Arun District Council
Arun Civic Centre
Maltravers Road
Littlehampton
West Sussex BN17 5LF
Planning & Building Control General Enquiries
Tel: (01903) 737756 Fax: (01903) 730442
Dx: 57406 Littlehampton
Minicom: 01903 732765
e-mail: planning@arun.gov.uk
website: www.arun.gov.uk/planning

4th May 2022

Application No: EP/39/22/PL
Site Address: 29 Tamarisk Way East Preston BN16 2TE
Description of works: Variation of condition imposed under EP/157/20/HH relating to condition 2-plans condition to include the retention of original outbuilding to the south of garage rather than the approved enlarged outbuilding, slight change to orientation of garage, removal of chimney, introduction of small catslide roof portion on the western elevation, removal of browed eaves above windows to become flat eaves, removal of covered bench building and revert to the existing rainwater below ground rather than soakaways due to the reduction of the footprint.

Proposed Roof Plan
1469/NA18A
Scale 1:100 at A3 .

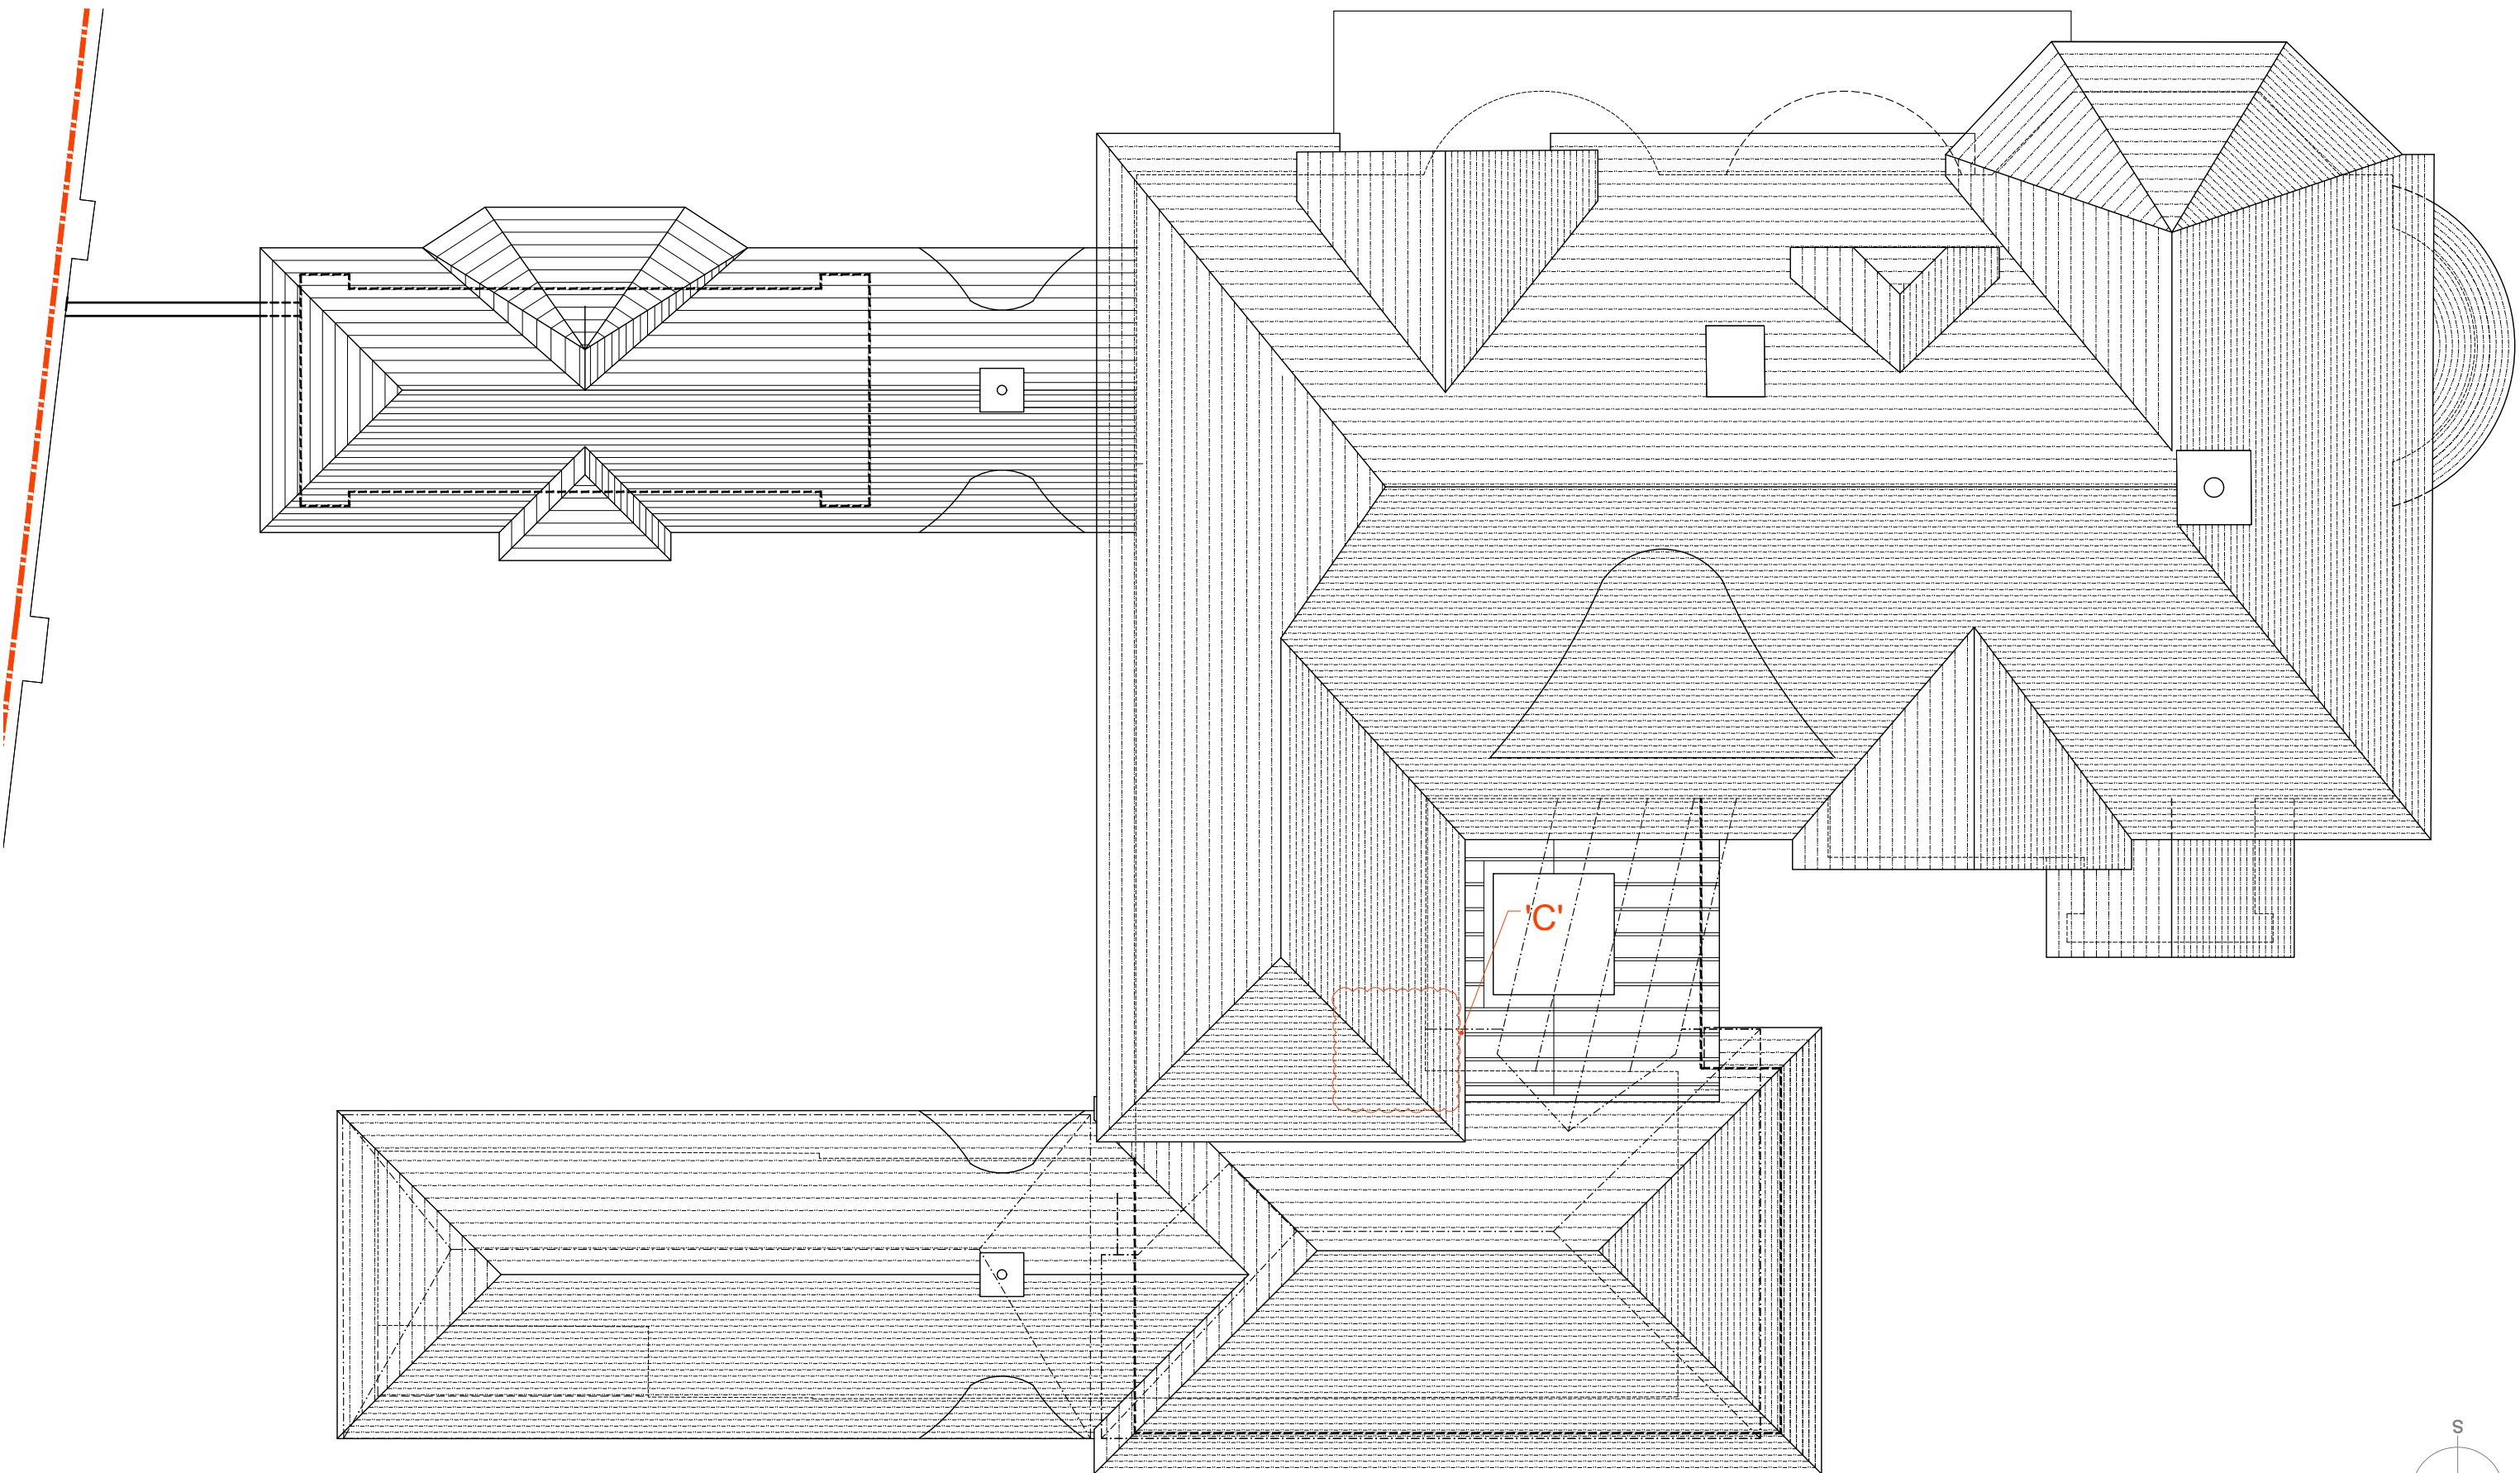
The original application granted on the second application was for the building to be of an arts and craft design, these changes do not represent an arts and craft style, the fascia has also been changed without being noted on the revised plans, the 1st floor eyebrow window has been enlarged from the original design without note?
